## RE: Feldmann Already Built

I am following up on our phone conversation and wanted clarity on what we'll need to submit for permit review for the Feldmann residence at 8059 West Mercer Way.

**SITE PLAN & PROJ DATA**

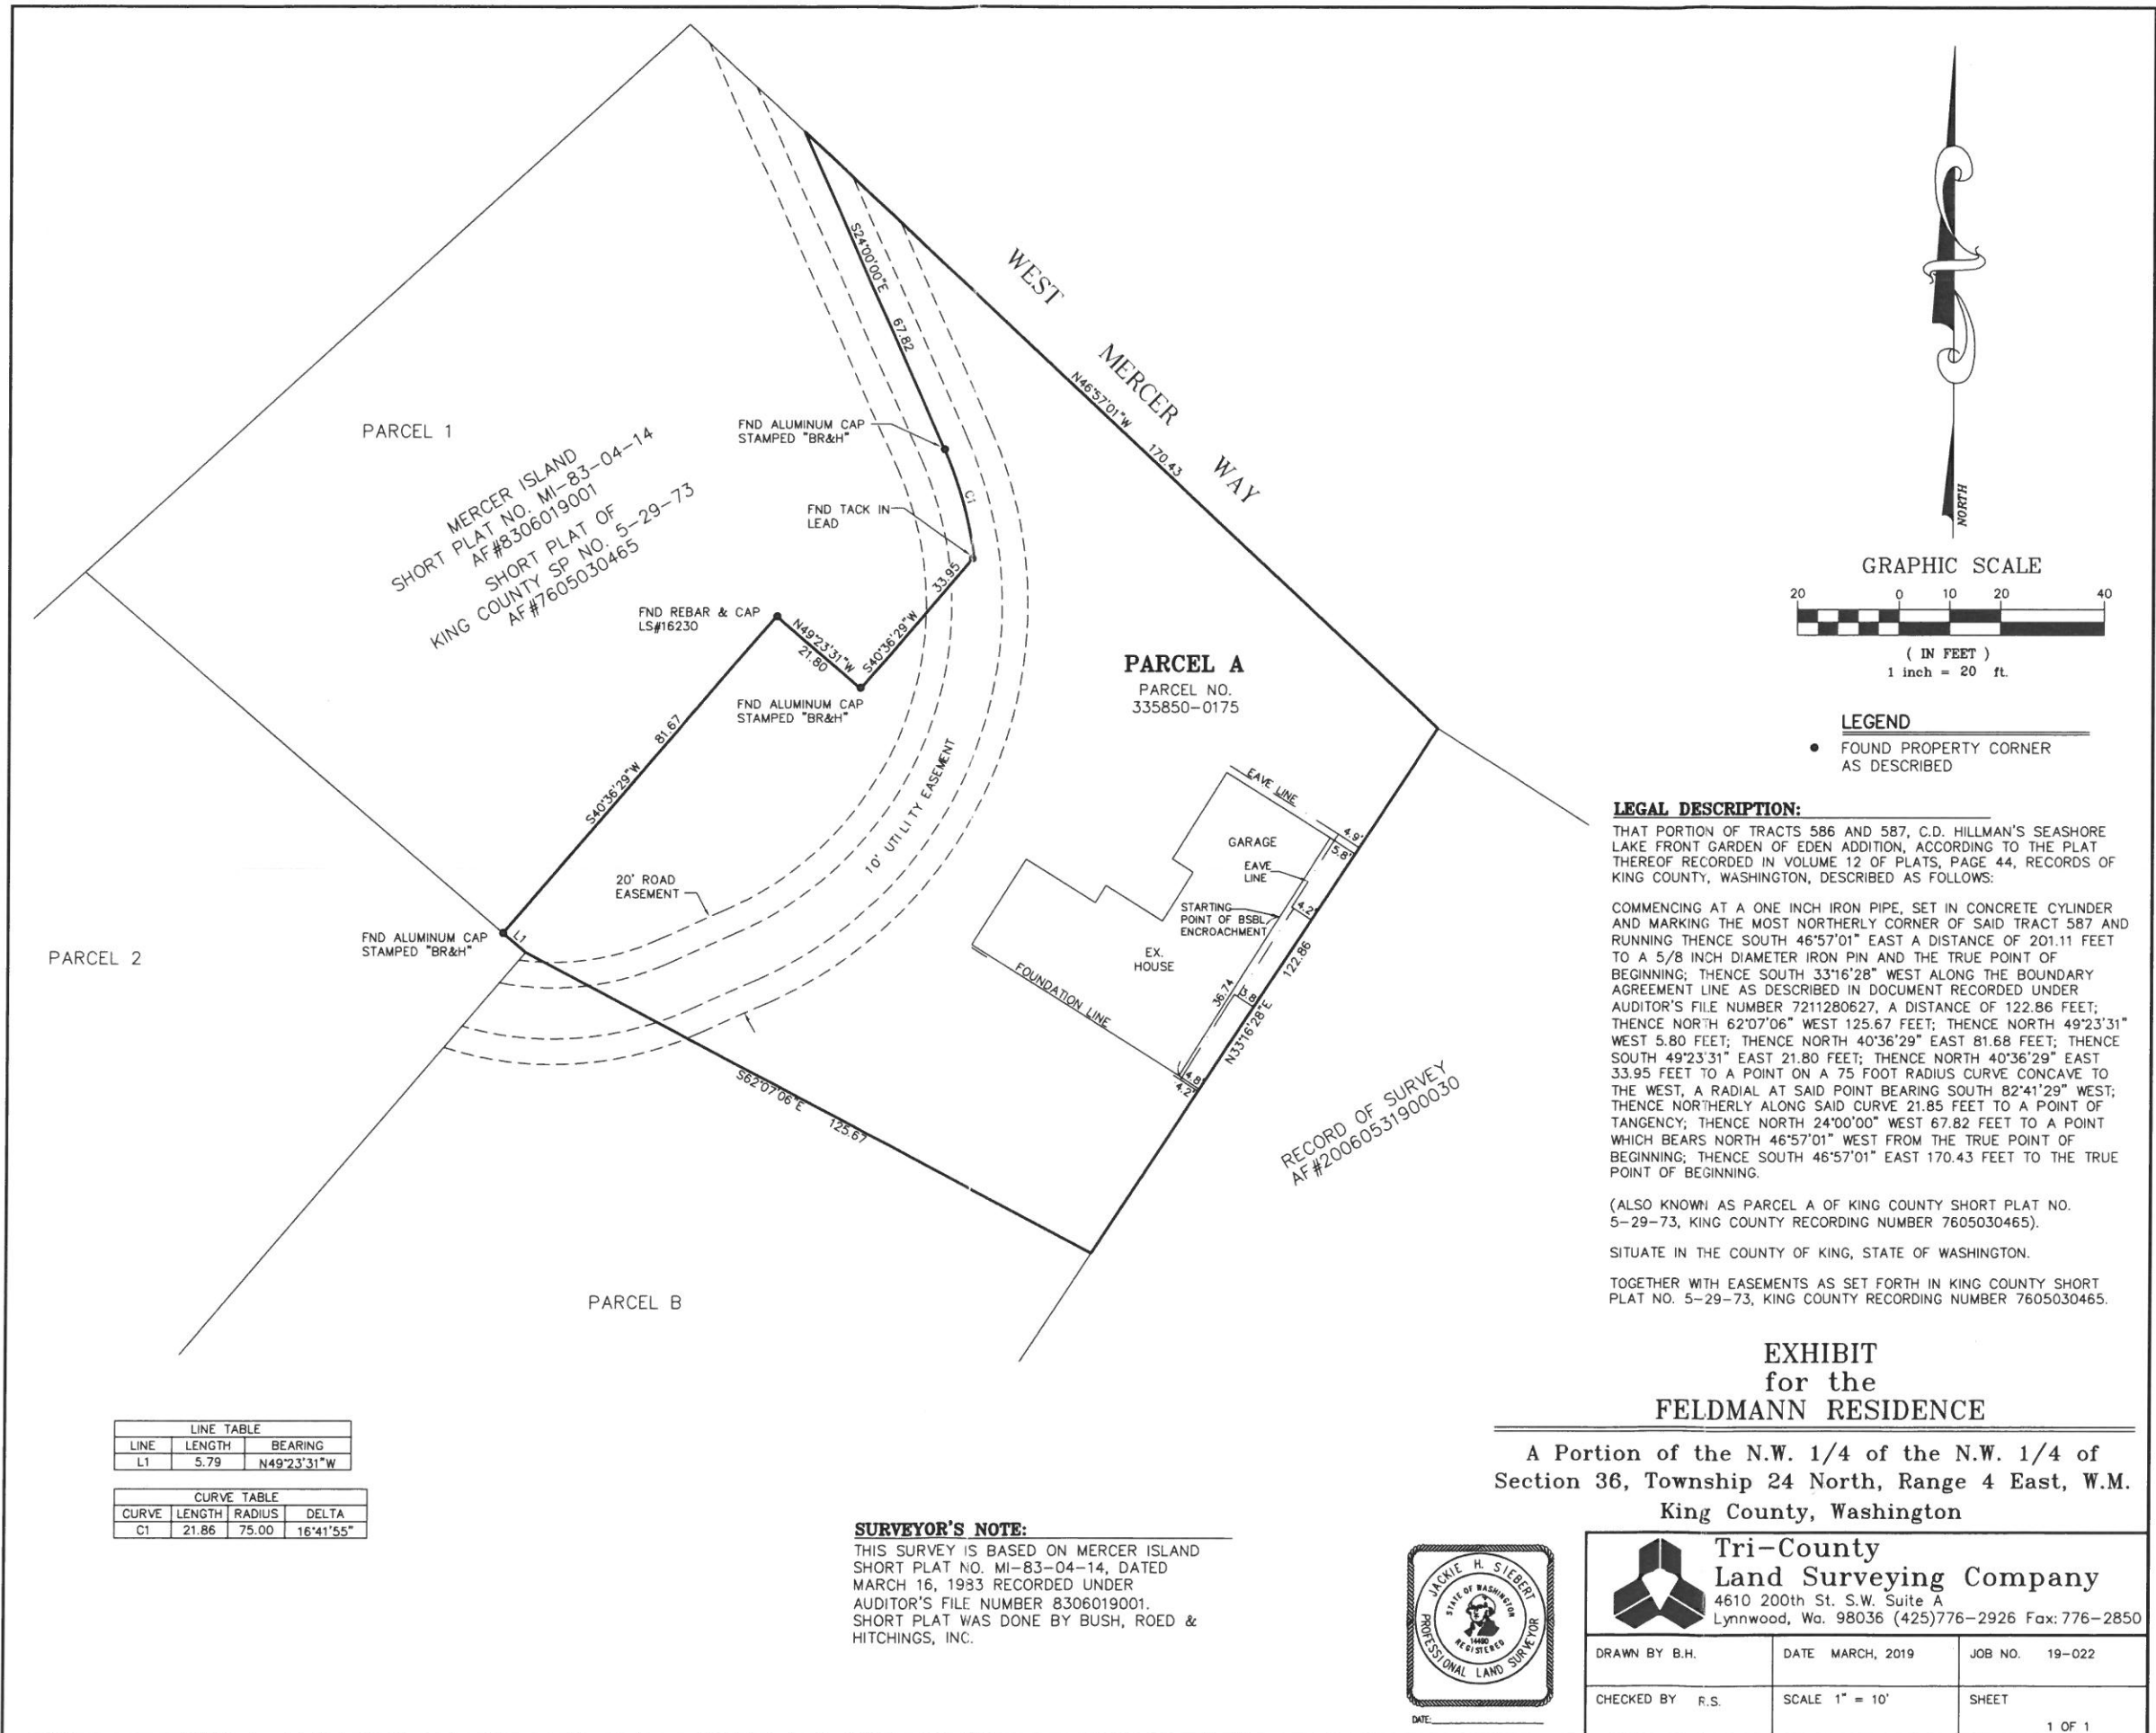
- Site plan/cover sheet (How detailed? Trees? Topo? )
  - Since the already built is over the pre-existing footprint, do we have to have imperv calcs?
- Survey – just metes and bounds with home located accurately relative to prop lines
- Basement floor plan- note no work this level
- Main floor plan
- Upper floor plan
- Roof plan
- (1) elevation only – North elevation/front entry showing addition over garage
- (1) building section @ ½"=1'-0" (do we need to show the new stair section?)
- Window & doors will be called out on floor plans w/ energy code requirements
- All structural drawings & calculations

- Site plan/cover sheet (How detailed? Trees? Topo? ) Yes, depict trees, no topo needed.
  - Since the already built is over the pre-existing footprint, do we have to have imperv calcs? Yes
- Survey – just metes and bounds with home located accurately relative to prop lines
- Basement floor plan- note no work this level
- Main floor plan
- Upper floor plan
- Roof plan
- (1) elevation only – North elevation/front entry showing addition over garage
- (1) building section @ ½"=1'-0" (do we need to show the new stair section?) No, just add the stair notes pertaining to rise/run, handrail height and diameter, ceiling height.
- Window & doors will be called out on floor plans w/ energy code requirements
- All structural drawings & calculations
